## Office of Environment & Heritage

Your reference: SSD-5156  
Our reference: DOC13/46164; FIL12/4055  
Contact: Steve Lewer, 4908 6814

### RE: REVIEW OF ENVIRONMENTAL IMPACT STATEMENT FOR GLOUCESTER RESOURCES LTD ROCKY HILL COAL PROJECT, GLOUCESTER (SSD- 5156)

## **ATTACHMENT A: OEH REVIEW OF ROCKY HILL COAL PROJECT EIS – OUTSTANDING ISSUES**

Figure 5.8
TERRESTRIAL ECOLOGY
STUDY AREA

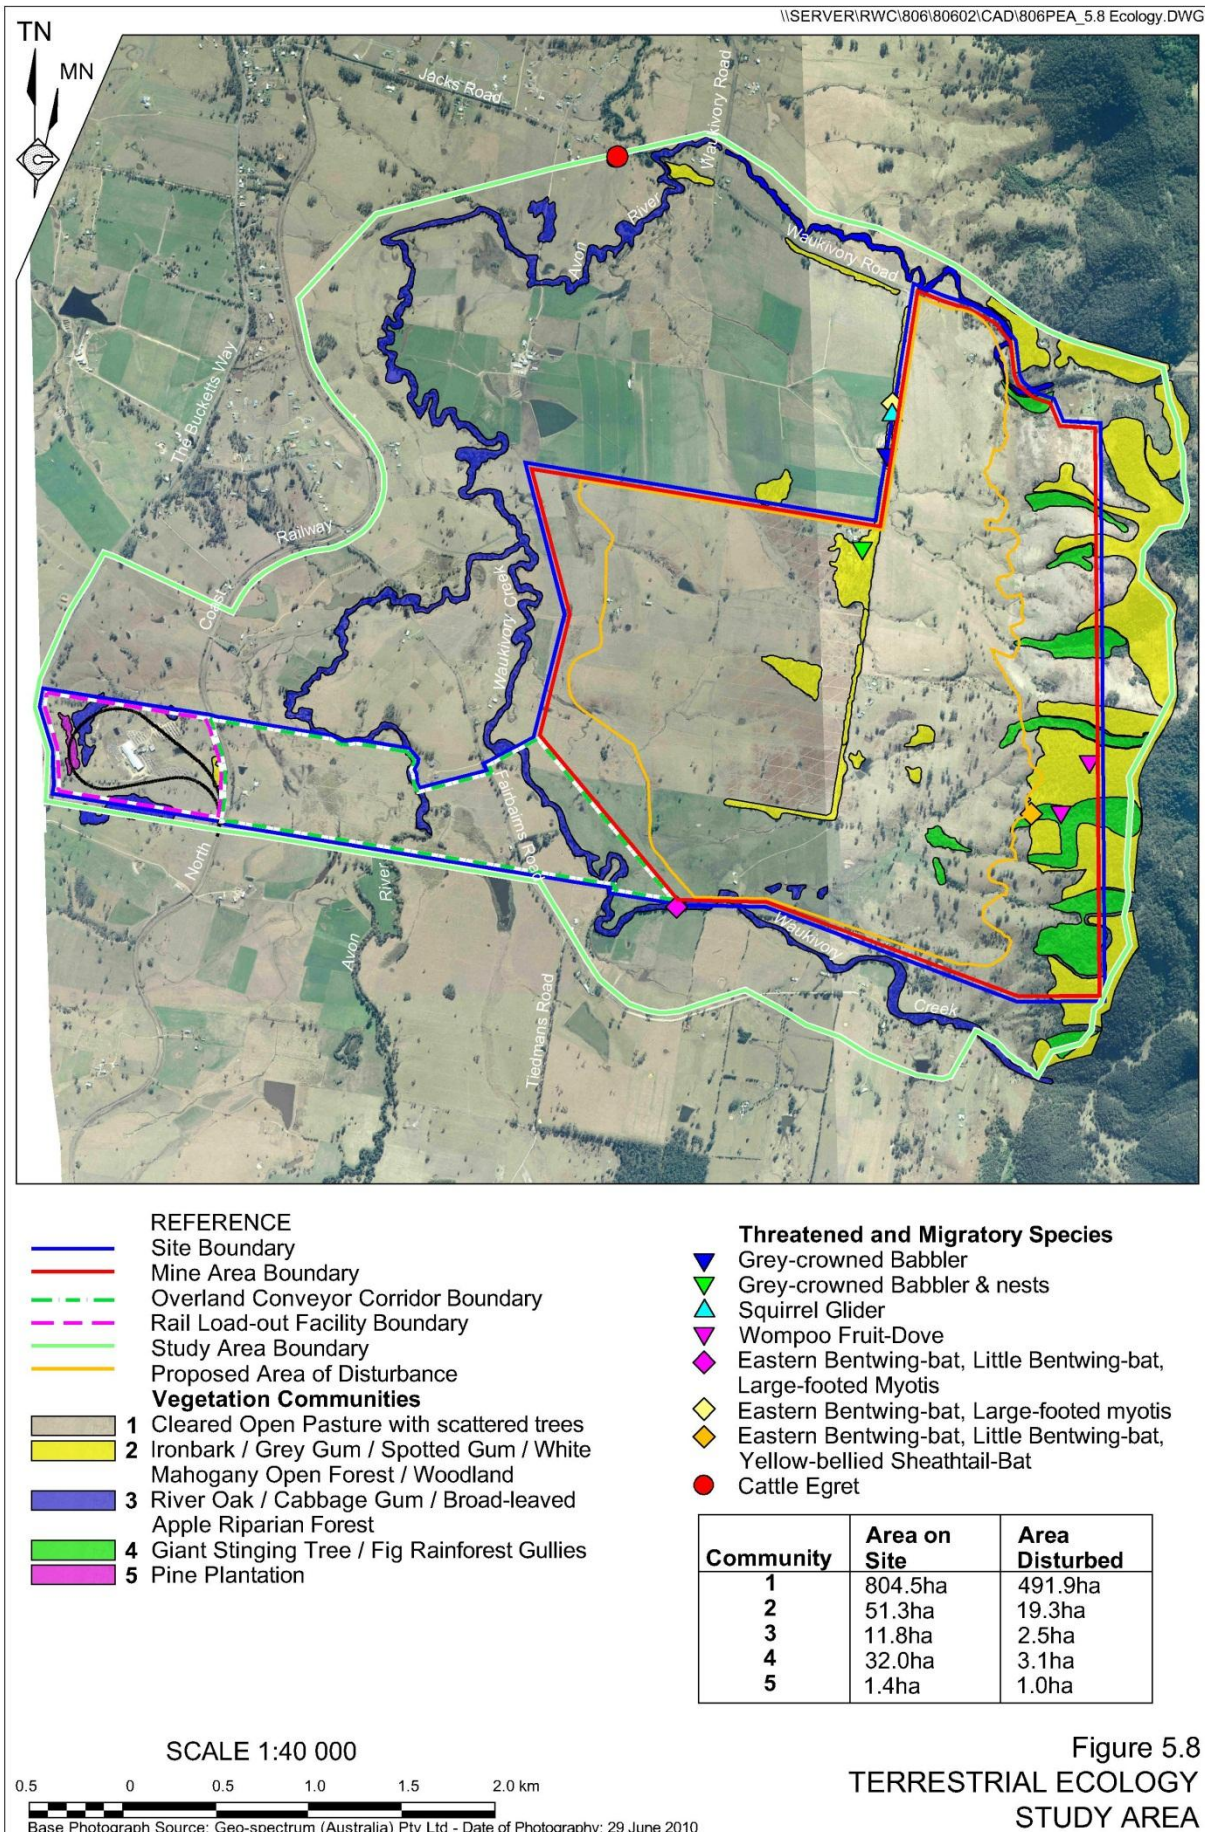
With respect to the vegetation types recorded on the development site and proposed biodiversity offset area (as specified in Section 3.1.3.1), further clarification and explanation of Community 4: Giant Stinging Tree / Fig Rainforest Gullies is required. In particular justification of how this community fits 'Lower Hunter Valley Dry Rainforest in the Sydney Basin and NSW North Coast Bioregions' vulnerable ecological community (VEC) and not the 'Lowland Rainforest in the NSW North Coast and Sydney Basin Bioregions' endangered ecological community (EEC). OEH is of the opinion that Community 4 equally if not better fits the Lowland Rainforest EEC, given that (i) more of the dominant species listed in the EIS are considered 'characteristic / diagnostic species' of this EEC (as per Paragraph 2 of the Final Determination), (ii) it has a closed structure, with a high diversity of rainforest trees, shrubs and vines consistent to Floyd (1990) *Dendrocnide excelsa* - *Ficus* spp. Alliance, which is considered to be a Lowland Rainforest type, (iii) it is located within the Stroud Valley within the Manning Valley which is consistent with the geographical distribution of the EEC in comparison to the VEC which appears to be restricted more to the Hunter Valley (i.e. the VEC Final Determination does not list Gloucester LGA as part of its geographic distribution), (iv) it occurs on the appropriate landscape features and substrate, that being steep drainage lines on footslopes / foothills on basalt, and (v) this EEC includes more structurally complex forms of dry rainforest, and as such better matches that described in the report.

- With respect to the biometric vegetation types (BVT) recorded on the development site, requests further justification why the rainforest type (Community 4) best fits 'Fig – Whalebone Tree – Stinging Tree dry rainforest of the southern North Coast (HU541)' in comparison to 'Giant Stinging Tree - Fig dry subtropical rainforest of the North Coast and Brigalow Belt South (HU548)' which appears to be a better fit based on the species descriptions in Section 3.1.3.1. This is a subtropical rainforest type, known to occur in dry gullies and lower slopes, to which OEH is of the opinion the BVT it should be annotated with the 'Lowland Rainforest in the NSW North Coast and Sydney Basin Bioregions' EEC (a subtropical rainforest) rather than 'Lower Hunter Valley Dry Rainforest in the Sydney Basin and NSW North Coast Bioregions' VEC (as explained above). OEH requires further justification of HU541 and the retention of the VEC status, or re-running the BBAM credit calculator.
